**Table 1. Response to Submission from Blacktown City Council**

Figure 6 Cable Place Intersection

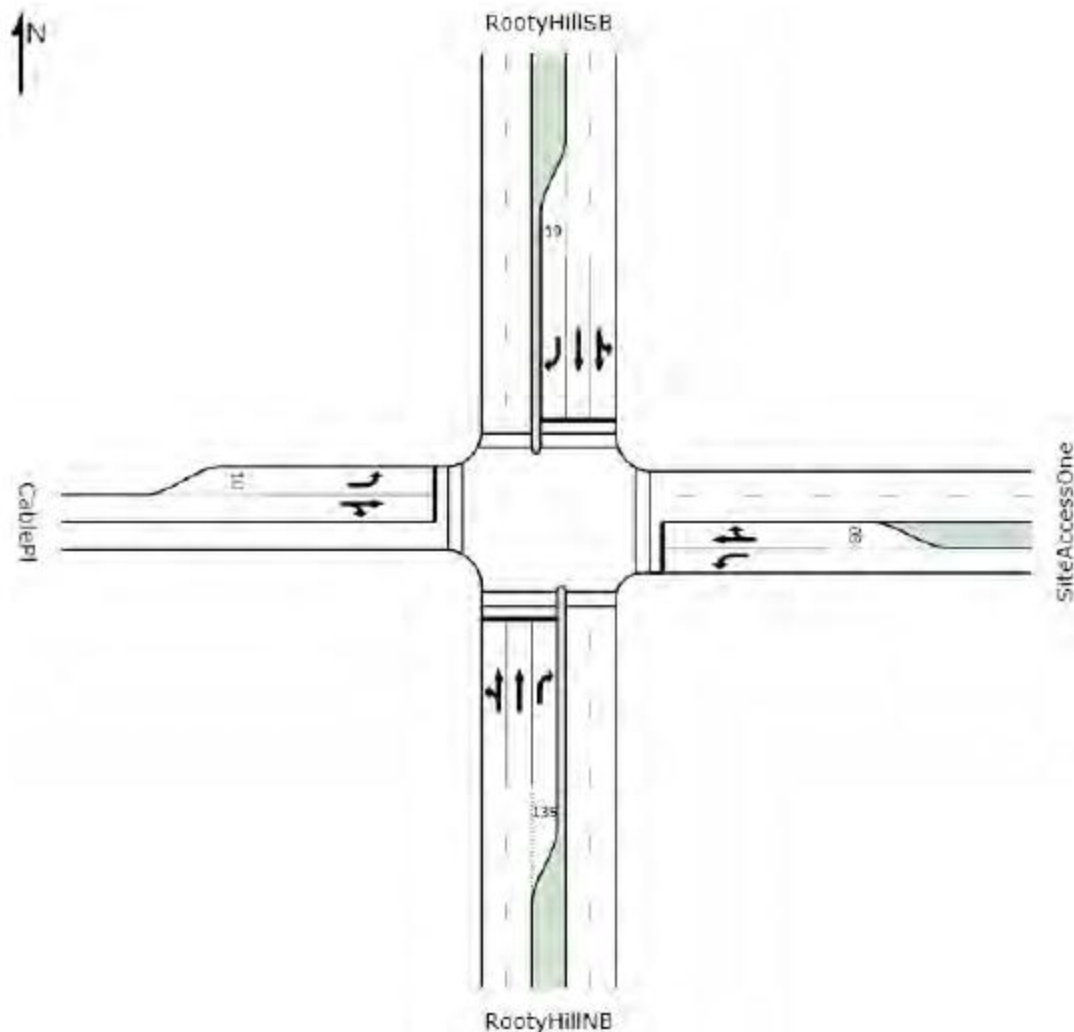
5. The proposed convenience retail in the village centre could attract people from adjacent residential areas. Due to safety concerns, measures need to be put in place to prevent people crossing the road at this location and encourage crossing at the signalised intersection.	<p>This issue is acknowledged and measures will be required. The RMS and Council have recommended future installation of a central median to Rooty Hill South Road, that can later accommodate a fence to deter pedestrians crossing the road at these locations. Pedestrians would instead be encouraged to cross at the future signalised pedestrian crossings. The central median would have breaks in it to accommodate future right turn lanes travelling southbound along Rooty Hill South Road. The subdivision plan has been amended to accommodate a road widening for these future road improvements.</p> <p>NOTE: It is recognised that relocating the signalised access to a more central location as requested by RMS would be more favourable for pedestrian movements across RHRS; however, we recommend maintaining the Cable Place access location.</p>	Traffix & Architectus

**Figure 5 - Proposed Village Centre Trade Area**

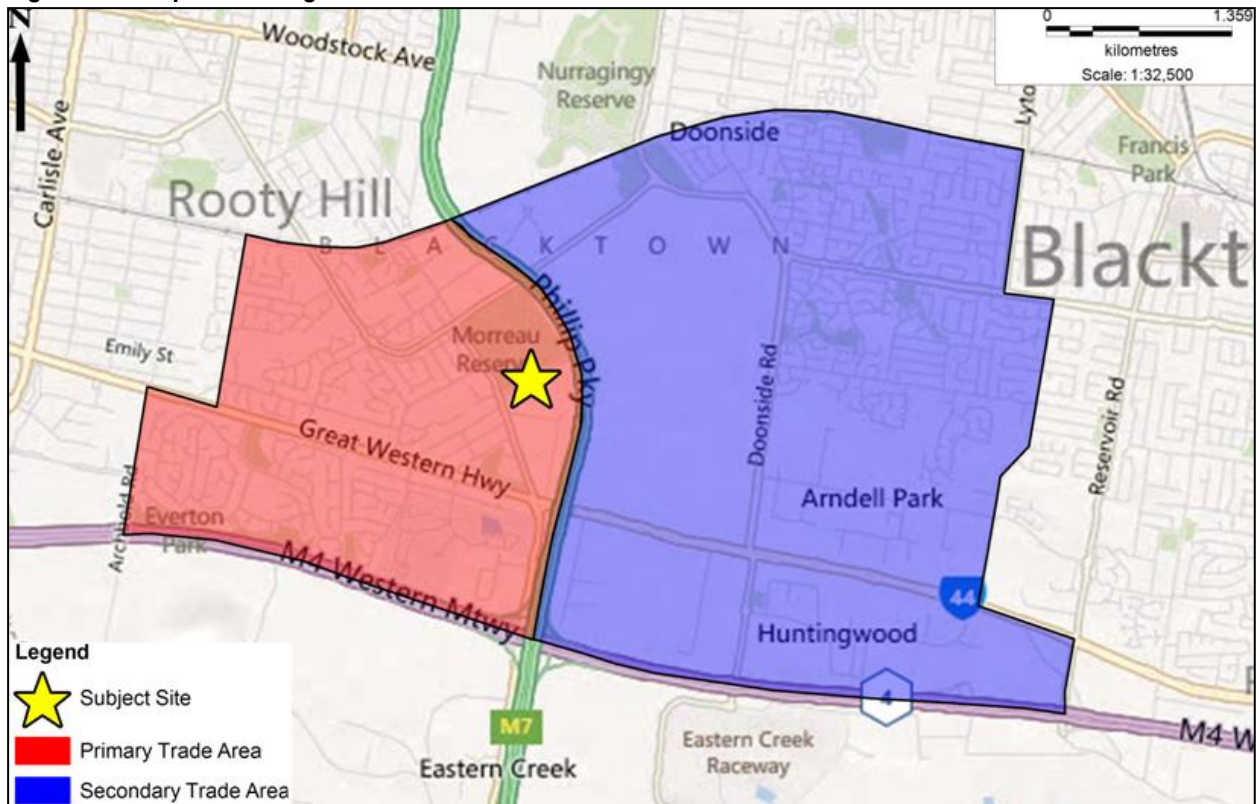
<p><b>3. Impact of retail centre trade area</b></p> <p>a. The EIS classifies the retail component of the proposal as a Village Centre. Yet the Metropolitan Plan for Sydney characterises village centres as up to 5,500 dwellings and walking catchment of 400-600 to medium density housing. Council will not increase densities in the area.</p>	<p>The EIA described the proposal as a Village Centre due to its proposed size, scale and retail mix of the retail and business premises floorspace proposed (supermarkets and specialty shops). It is the appropriate size and retail mix of a Village Centre, notwithstanding the fact that there is not medium density surrounding it. In any case the definition in the Metropolitan Plan is a broad guide for classification purposes and is not meant to be prescriptive.</p>	Hill PDA
<p>b. The identified trade area of Rooty Hill Centre covers half of the Rooty Hill Centre. The proposal will therefore significantly</p>	<p>As indicated in the EIA and Supplementary Report, in the MPD report the village centre component:</p> <p><i>The primary trade area (PTA) is defined as comprising parts of Minchinbury</i></p>	Hill PDA

Figure 6 - Proposed Bulky Goods and Large Format Retail Store Trade Area

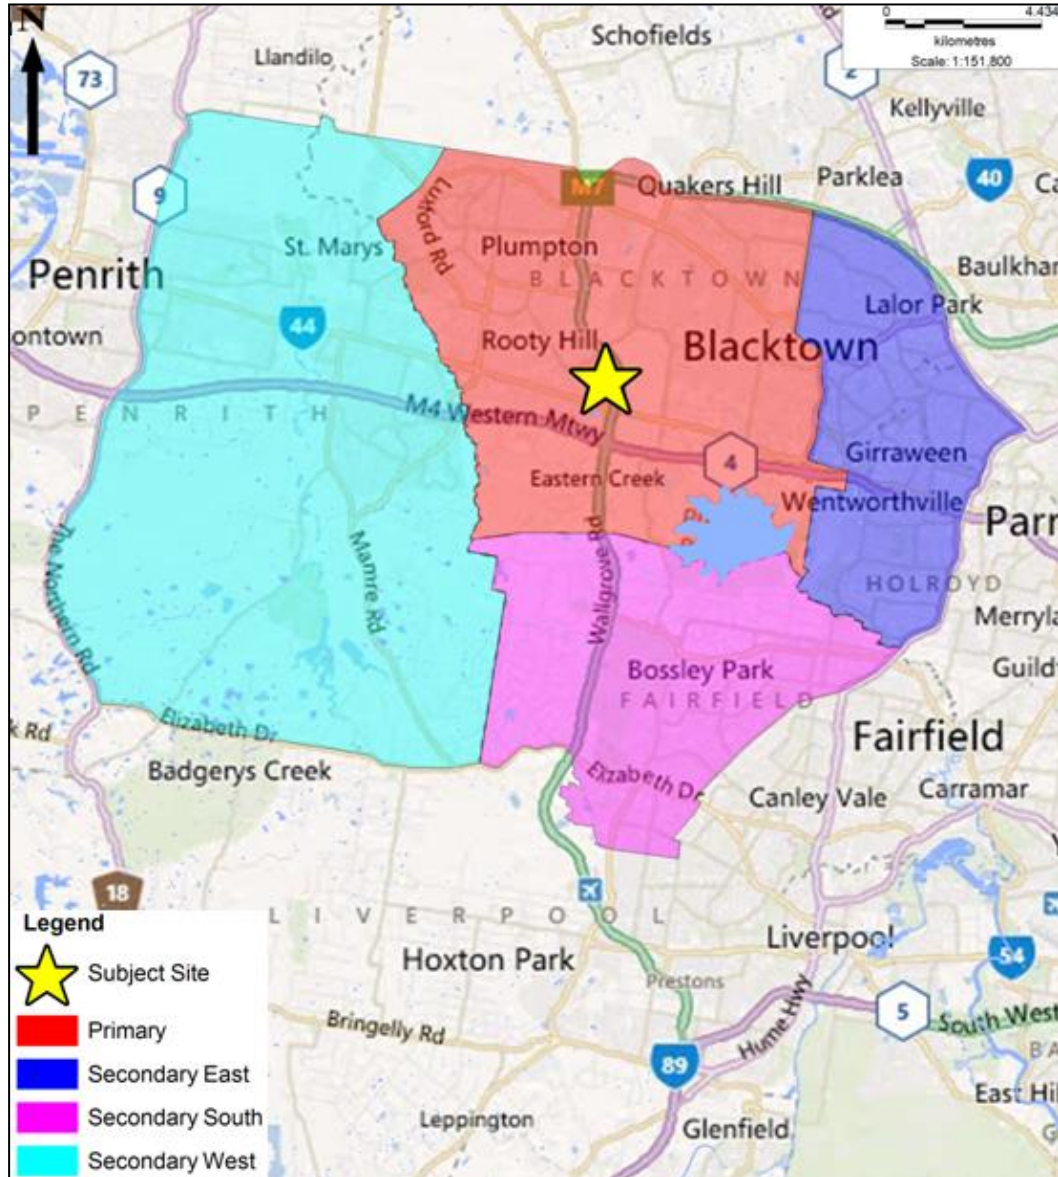
<p><b>4. Inadequate identification of bulky goods trade area.</b></p> <p>The trade area identified in the EIS appears extremely limited given the proposed floorspace.</p> <p>Fails to acknowledge existing regional road networks.</p> <p>Fails to mention the significant employment area of Marsden Park Industrial Precinct in the North West Growth Centre.</p>	<p>The EIA does consider Marsden Park and the growth centres in defining the bulky goods trade area as follows: (page 34-35):</p> <p><i>"The potential to attract bulky goods expenditure from residents beyond the Main Trade Area (MTA) to the south is likely to be limited given the distances involved and the extent of existing and planned future bulky goods floorspace in this area. Significant bulky goods provision is planned as part of the South West Growth Centre (e.g. Leppington Major Centre and Crossroads), and therefore the extent to which residents would be prepared to travel from this area to Eastern Creek to purchase bulky goods is likely to be limited.</i></p> <p><i>The potential to attract spend from MTA to the north is likely to be limited particularly due to the 50,000sqm of bulky goods floorspace planned at Marsden Park which will include a Bunnings and possibly an IKEA. There is also considerable bulky goods provision in the likes of Castle Hill, Rouse Hill Major Centre and Baulkham Hills which are meeting the immediate needs of these residents.</i></p> <p><i>The strength of existing provision in the likes of Penrith, Castle Hill, Parramatta and Auburn will limit the extent of the bulky goods MTA to the east and west."</i></p> <p>Note that in peer reviewing the economic related documentation associated with this proposal, SGS concurred with the extent of the bulky goods trade area which Hill PDA defined. SGS note that:</p> <p><i>"In general, the defined trade area for bulky goods retailing on the subject site is considered appropriate, given the potential to attract bulky goods expenditure from residents outside the MTA is limited by either the travel</i></p>	Hill PDA
